REF: Mt Pleasant Coal Mine Modification 4 – Environmental Assessment

I refer to the application from MACH Energy ("the Proponent") for Modification 4 of the Mt Pleasant mine approval DA 92/97. I am pleased to provide the following submission on behalf of Muswellbrook Shire Council ("Council") with respect to the Proponent's Environmental Assessment (EA) dated December 2017.

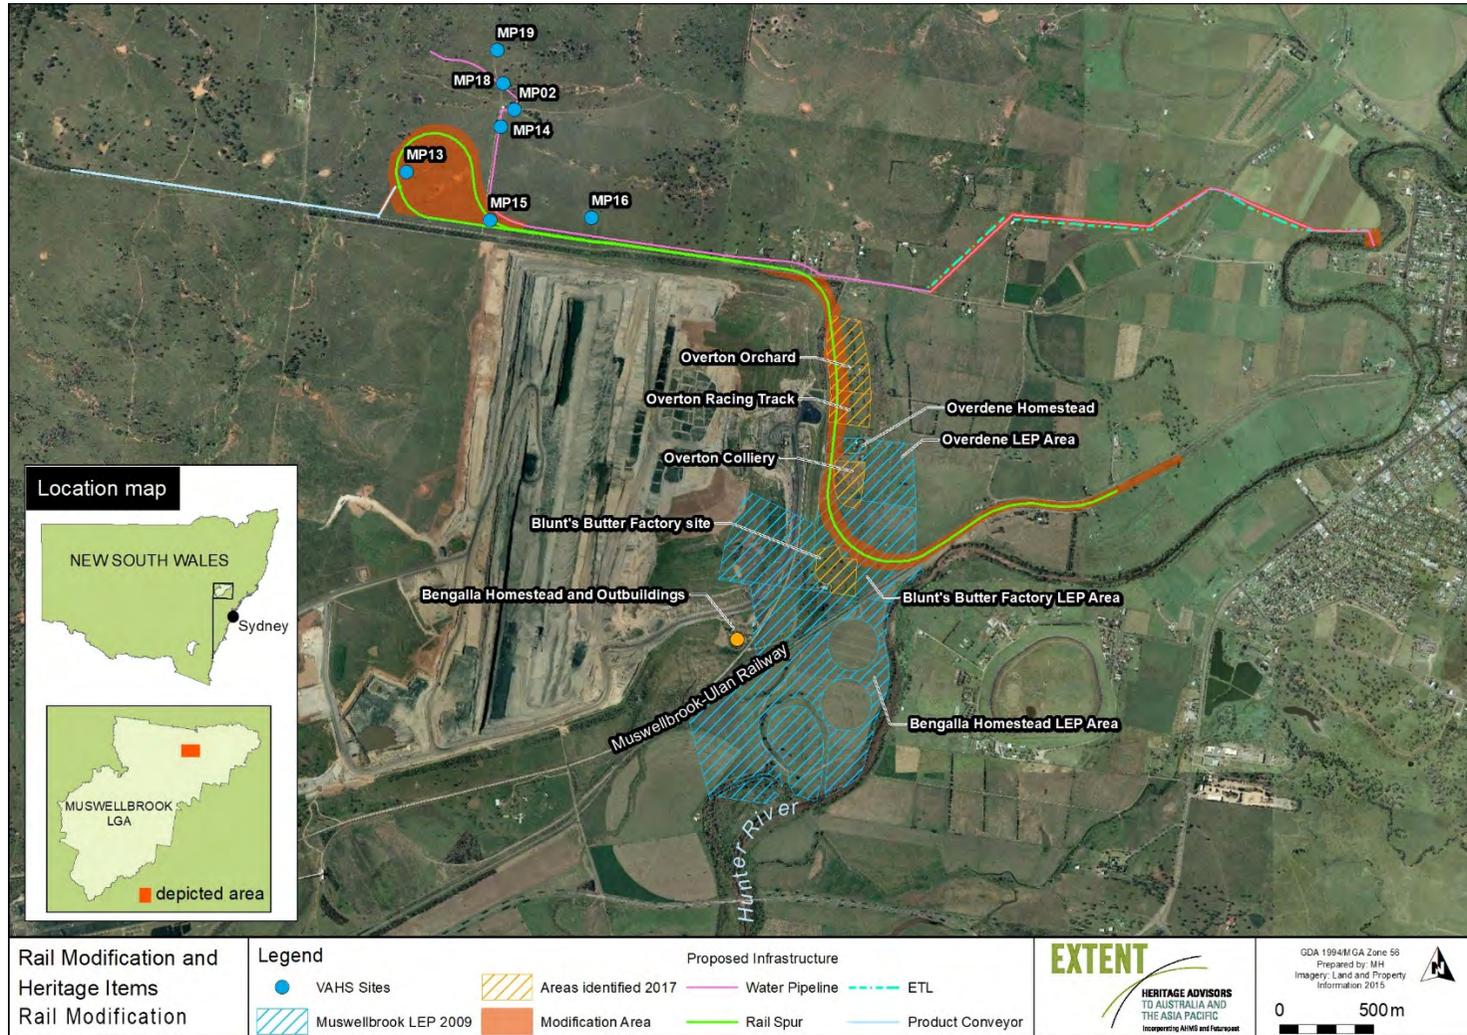
- vii. The two areas of cuttings in the side of the slope located east of Overton Orchard and the possible pump house (both illustrated in Figure 1 of the Statement of Heritage Impact), are to have movement of heavy machinery and vehicles prohibited and they are to be treated in line with clause iii. above.

Figure 33 Blunt's Butter Factory site map showing locations of features of interest, curtilage area and proposed rail alignment.

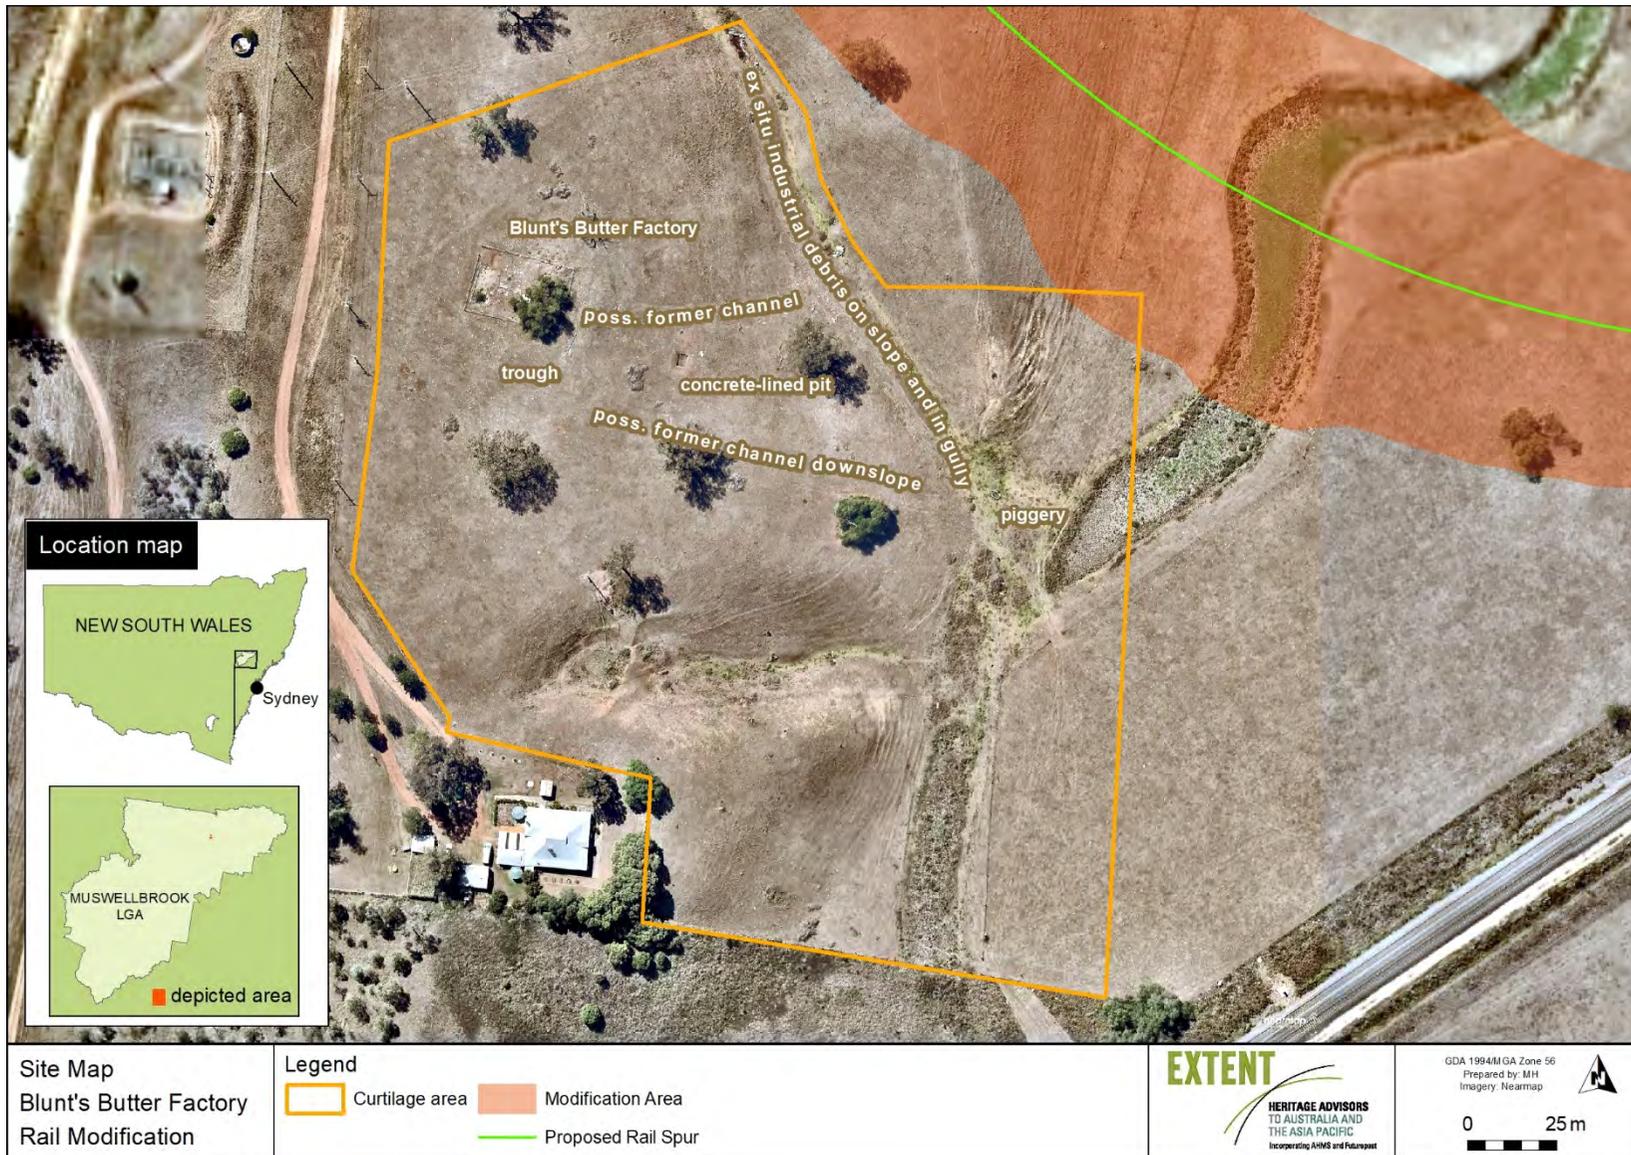
- iv. In those parts of the Overton Orchard and Race Track that will be retained, the extant cultural plantings are to be retained in situ.
- v. The movement of heavy vehicles and machinery is to be prevented in and around Blunt's Butter Factory within the (curtilage) area bounded in orange in Figure 33 of Appendix F: Statement of Heritage Impact by Extent Heritage Pty Ltd (Extent) (2017). If construction requirements make this impossible, relevant contractors must work with an archaeologist to identify appropriate points of access and routes through the area of archaeological sensitivity. Councils Heritage Advisor is to be consulted in line with clause iii. above.
